From: Sue Howell <Sue.Howell@arun.gov.uk>
Sent: 04 August 2026 16:40
To: Planning.Responses <Planning.Responses@arun.gov.uk>; Kathryn Welch <Kathryn.Welch@arun.gov.uk>
Subject: Planning Consultation on: A/43/26/PL

Application ref: A/43/26/PL

Description: Erection of 19 No dwellings. This application is in CIL Zone 2 and is CIL Liable as a new dwelling.

Location: Broadlees Dappers Lane Angmering BN16 4EN

Layout: Open Space and Play Space Provision

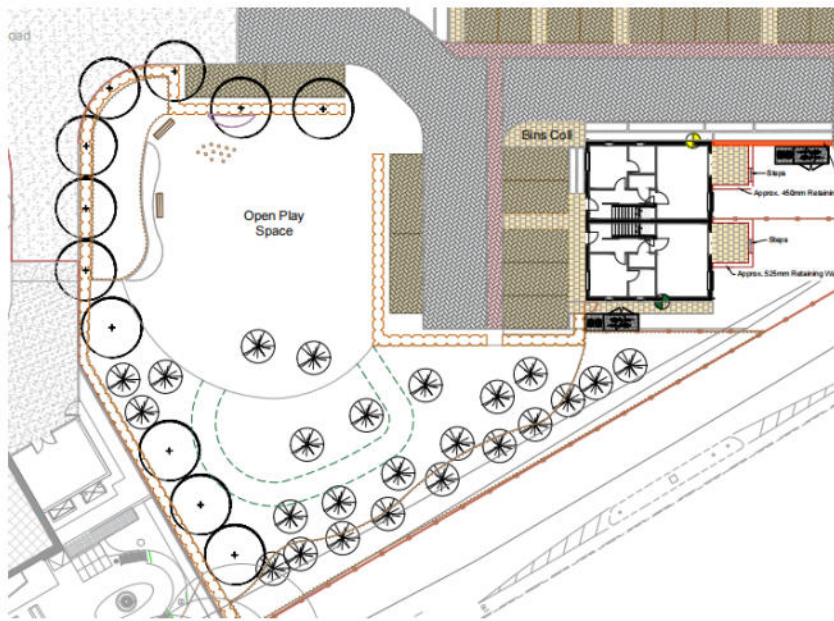
The Schedule of Accommodation indicates 1705sqm of POS being provided with this development, confirmation of this should be sought to ensure that it meets our SPD requirements. There is a requirement for 1338m² of POS or 1568m² with play to be provided for a development of 19 dwellings.

Based solely on the Schedule of Accommodation figure of 1,705m² the proposal appear to meet the ADC Open Space SPD 2020 public open space quantum requirement derived from 19 dwellings at 2.2 persons per dwelling. Compliance is dependent upon the extent to which the 1,705 m² comprises usable public open space rather than incidental landscaping, highway verges, drainage infrastructure or other areas that would not normally be regarded as functional public open space.

The Schedule of Accommodation identifies 1,705 m² of open space, and that figure includes:

- the main equipped play/open space,
- the open space at the frontage,
- grass verges within the development,

Recommend **no landscape objection** to the proposals within this A/43/26/PL application. POS quantum recommended be confirmed.

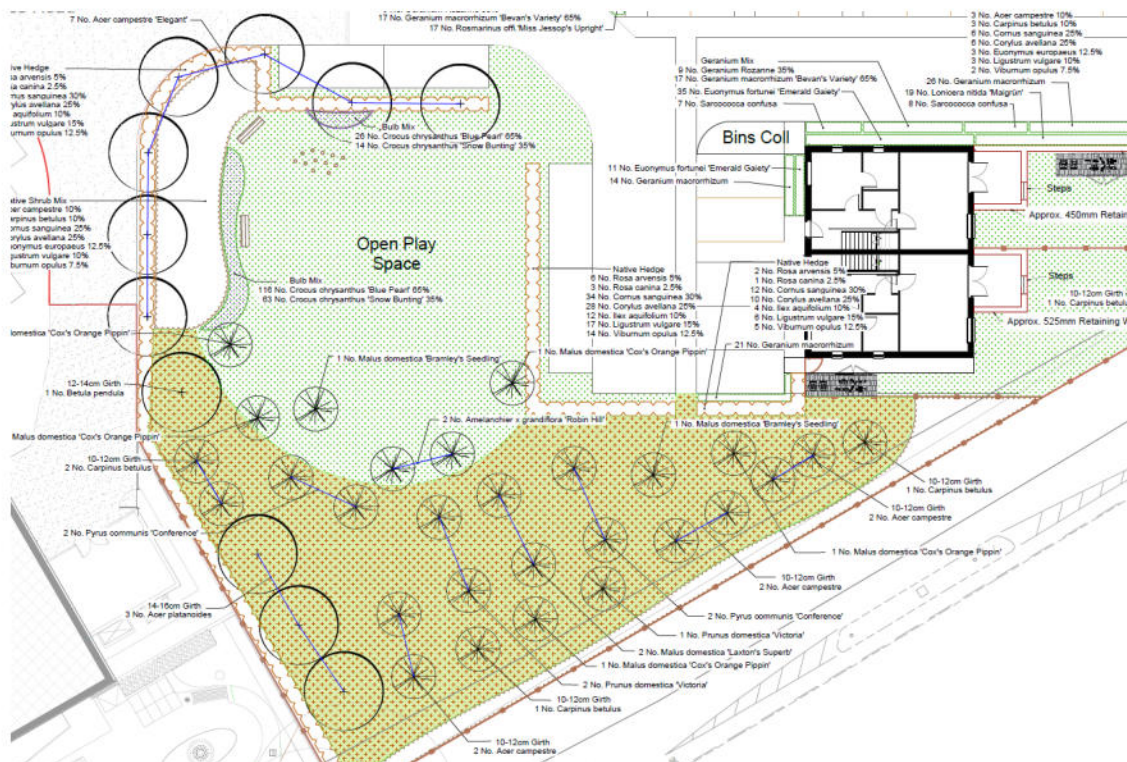
A development of this size will require the provision of onsite POS plus the provision of onsite, unequipped natural play LAP, which does appear to have been included within the application. The LAP will need to be a landscaped area and will need to include such features as landform, boulders or logs, seat and litter bin.
